Appeal Decision

Appeal Ref: APP/R5510/W/18/3195627
52 Field End Road, Ruislip HA5 2QN

- The appeal is made under section 78 of the Town and Country Planning Act 1990 against a refusal to grant planning permission.
 - The appeal is made by Mr Neil Richardson against the decision of the Council of the London Borough of Hillingdon.
 - The application Ref 4913/APP/2016/4358, dated 30 November 2016, was refused by notice dated 11 September 2017.
 - The development proposed is "Conversion of, and extension to, existing 4-bedroom dwelling into 2 new dwellings; and construction of new 3-bedroom dwelling".
-

Highway Plan 1:200

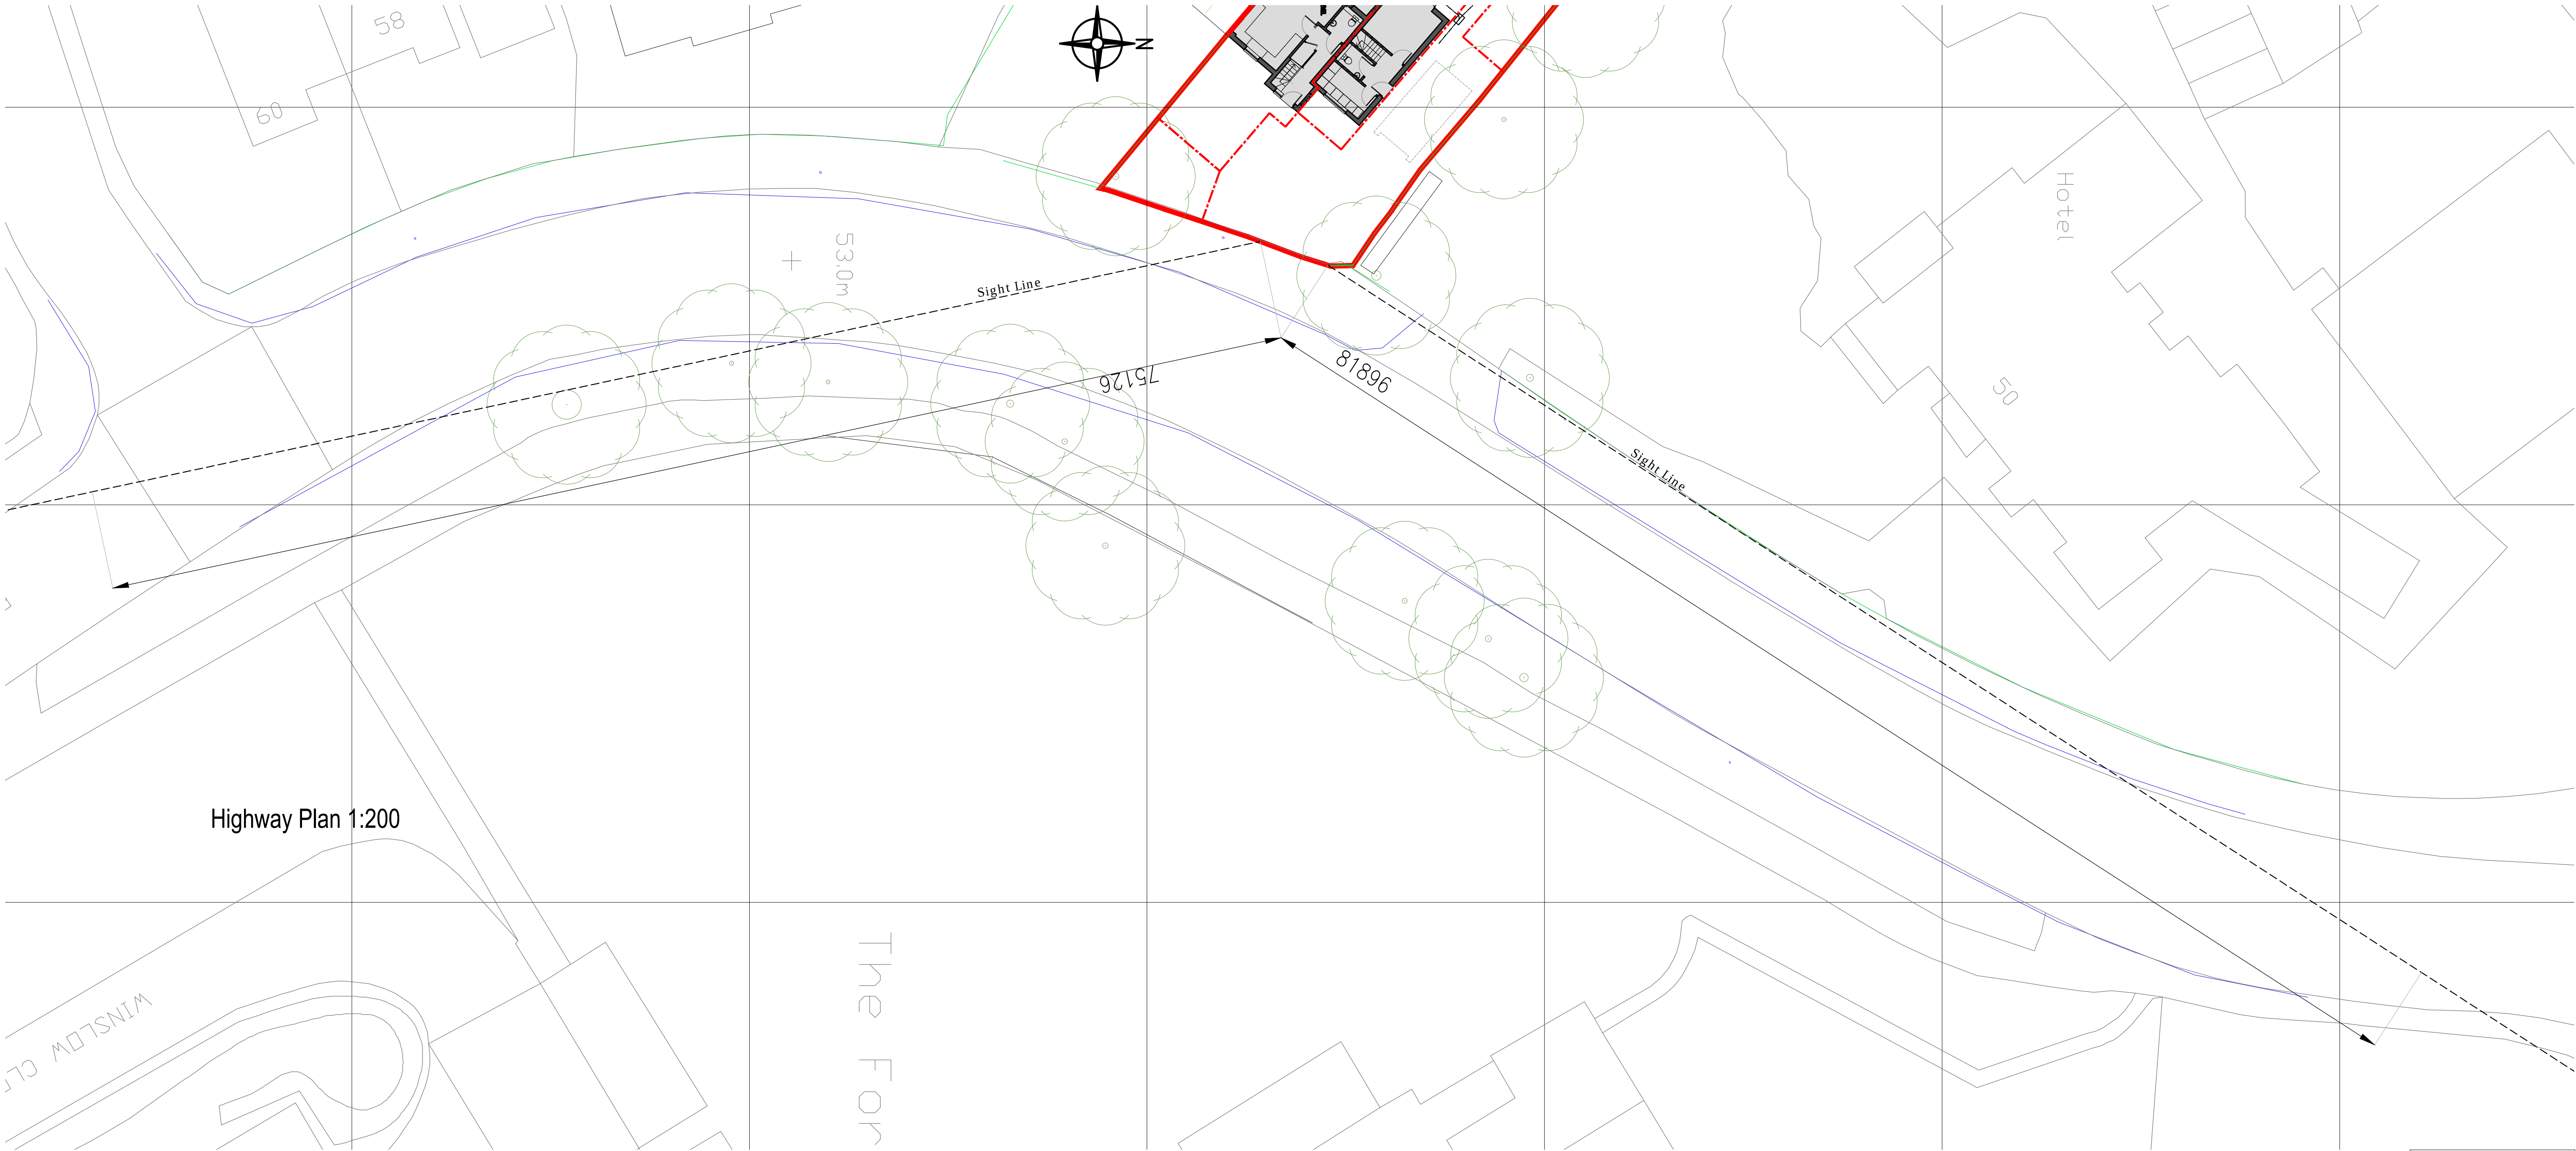
9. The proposed parking spaces would be sited adjacent to the rear boundary fence of No 54. This would generate vehicle movements and vehicle manoeuvring in close proximity to it that would considerably increase the level of noise experienced by the occupiers of No 54 when using their rear garden. It would also be likely to increase noise levels by a marked degree to any rear facing rooms within No 54, particularly during the summer months when doors and windows are more likely to be open for ventilation. I also share the Council's concern that the parking of vehicles in this location, given the orientation of the parking spaces, would be likely to result in headlight glare into some of the rear facing windows of No 54. This would unduly disturb the occupiers of this property, particularly when late in the evening or during the night.

10. The proposal would therefore result in an unacceptable level of noise and disturbance for the occupiers of No 54. This would give rise to considerable harm to their living conditions and would substantially reduce their enjoyment of their home and garden.
